The General Manager
Major Projects Assessment
GPO Box 39
SYDNEY NSW 2000

28 July 2010

**Provision of key issues and assessment for 32//1014864 Masonite Road
Heatherbrae 2324**

The RFS has reviewed the preferred project plan and provides the following advice:

PROPOSED INDUSTRIAL DEVELOPMENT
431 (LOT 32) MASONITE ROAD, HEATHERBRAE
SITE PLAN
SANDVIK MINING AND CONSTRUCTION AUSTRALIA PTY LTD
PROJECT BY HUNTER LAND DEVELOPMENTS

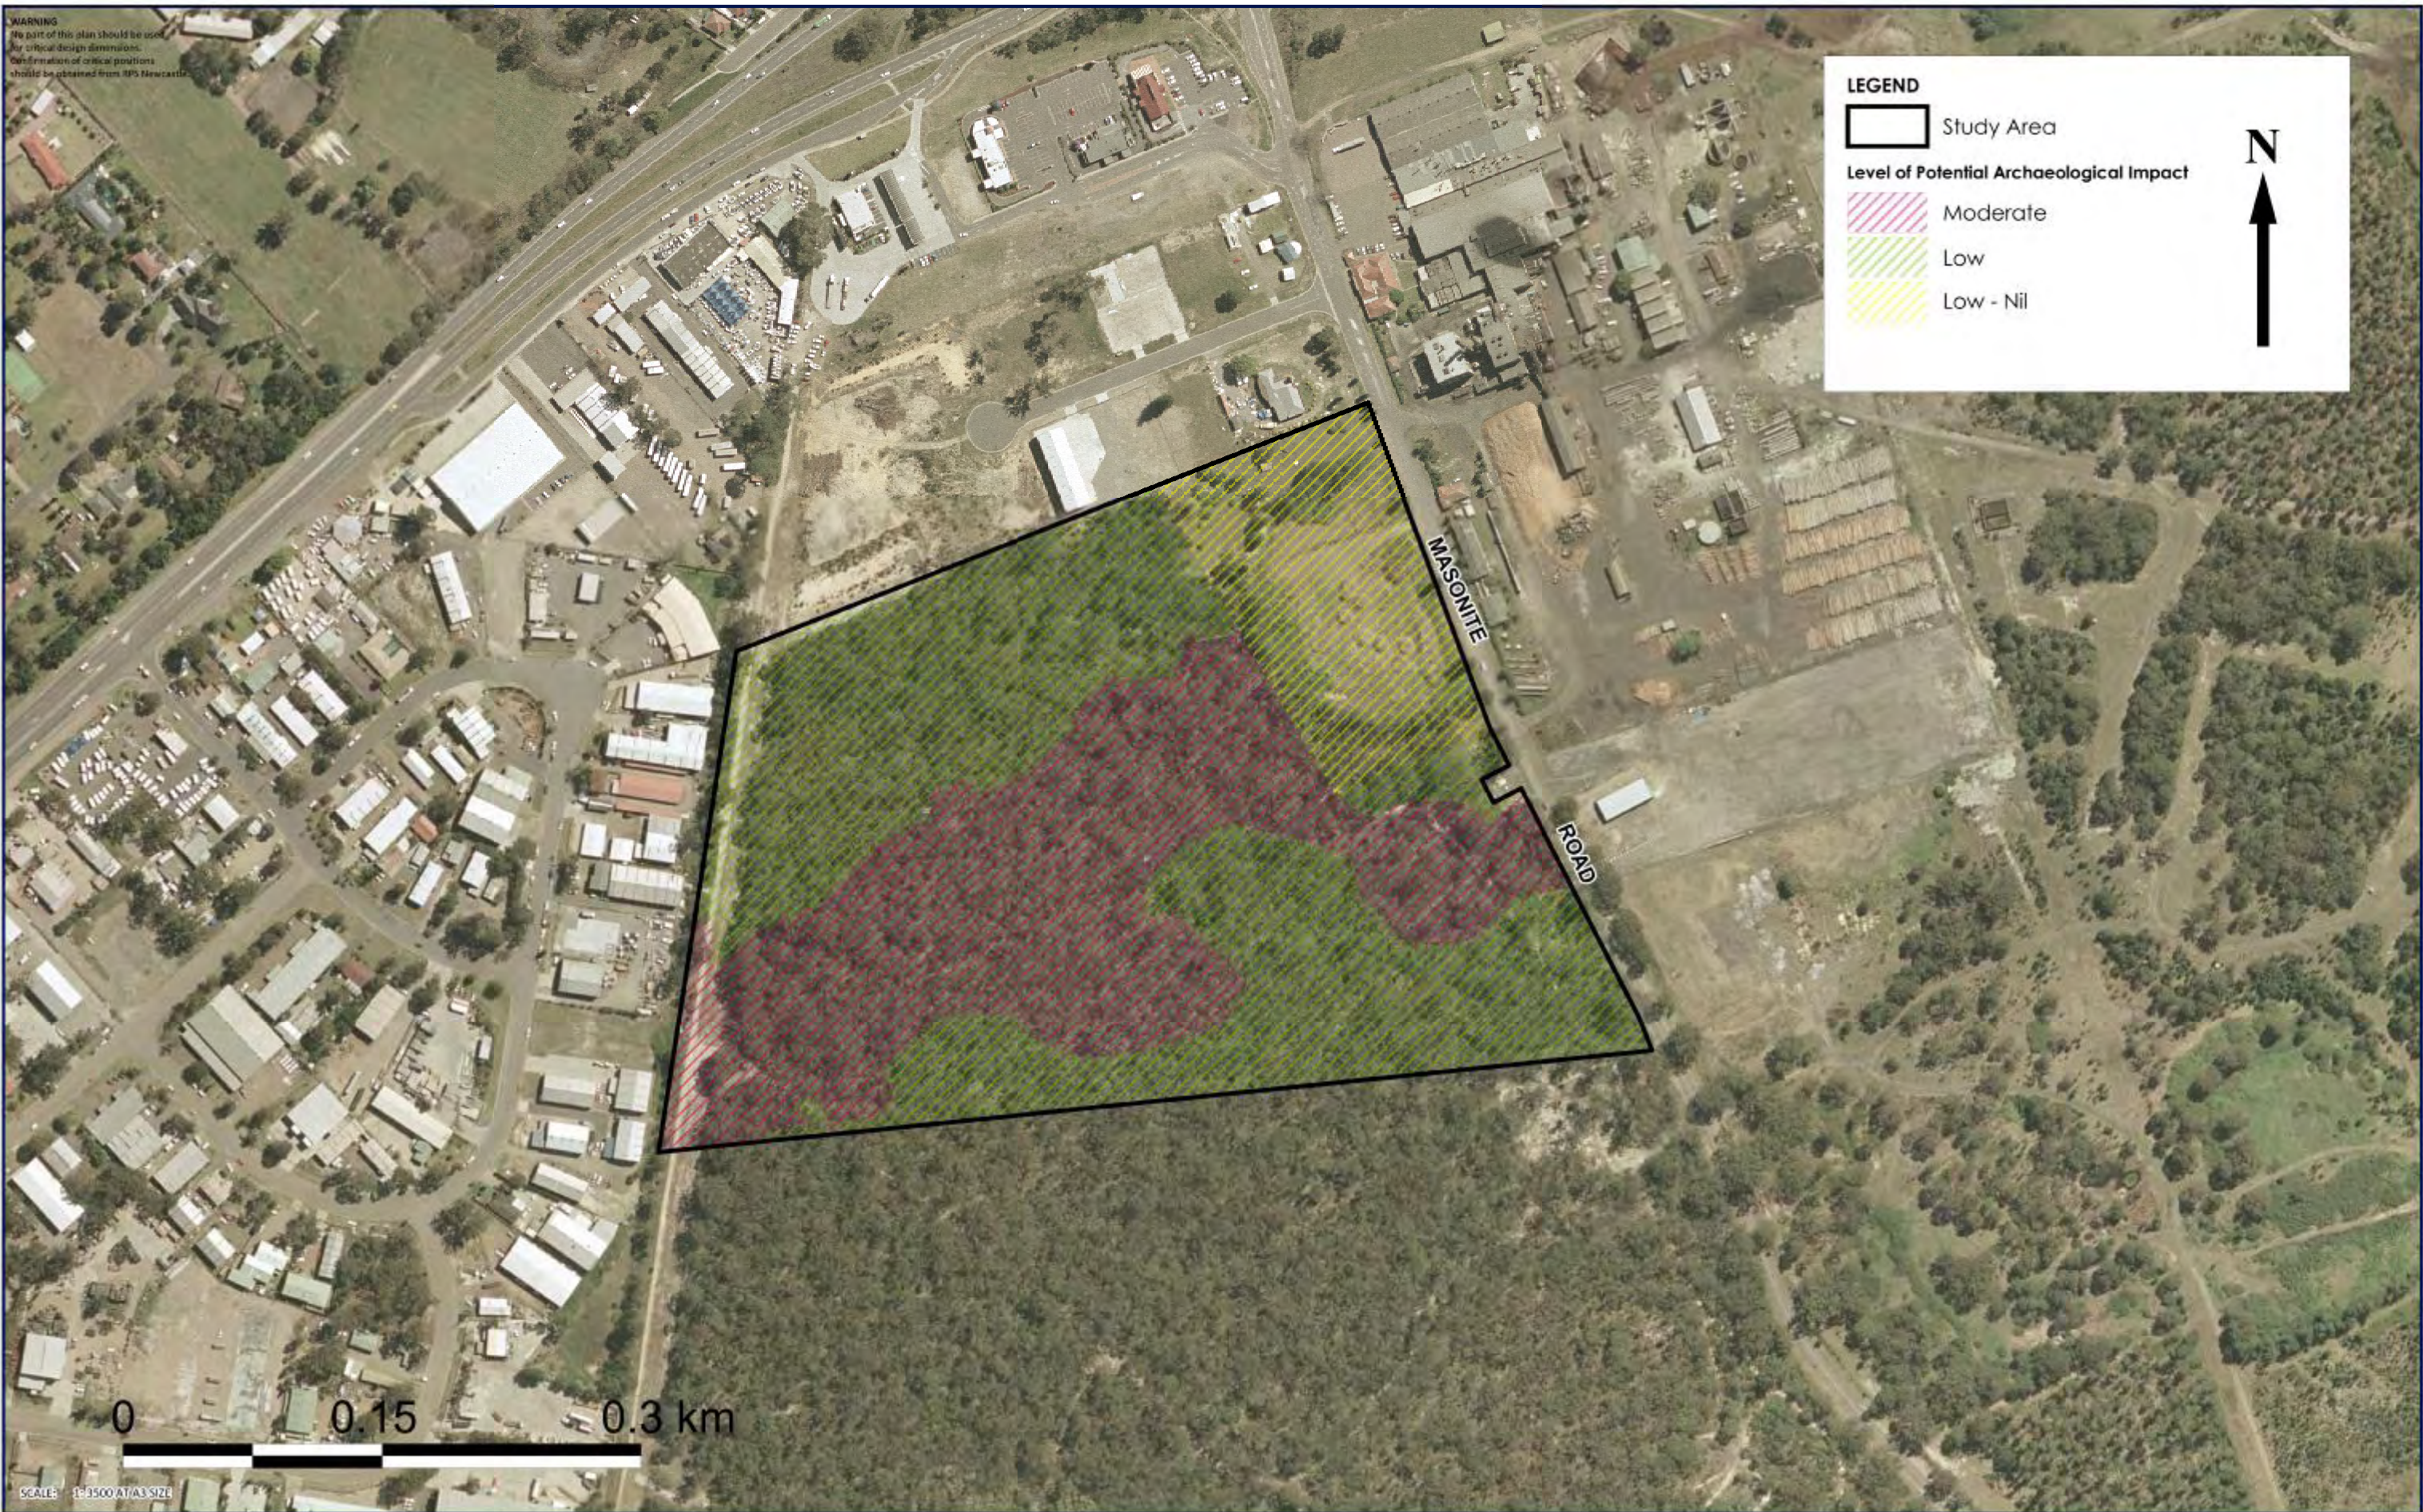
1. At the commencement of building works and in perpetuity, a 10 metre wide asset protection zone shall be provided along the southern property boundary and surrounding the retained vegetation onsite as an inner protection area (IPA) as outlined within Appendices 2 & 5 of *Planning for Bush Fire Protection 2006* and the NSW Rural Fire Service's document *Standards for asset protection zones*.
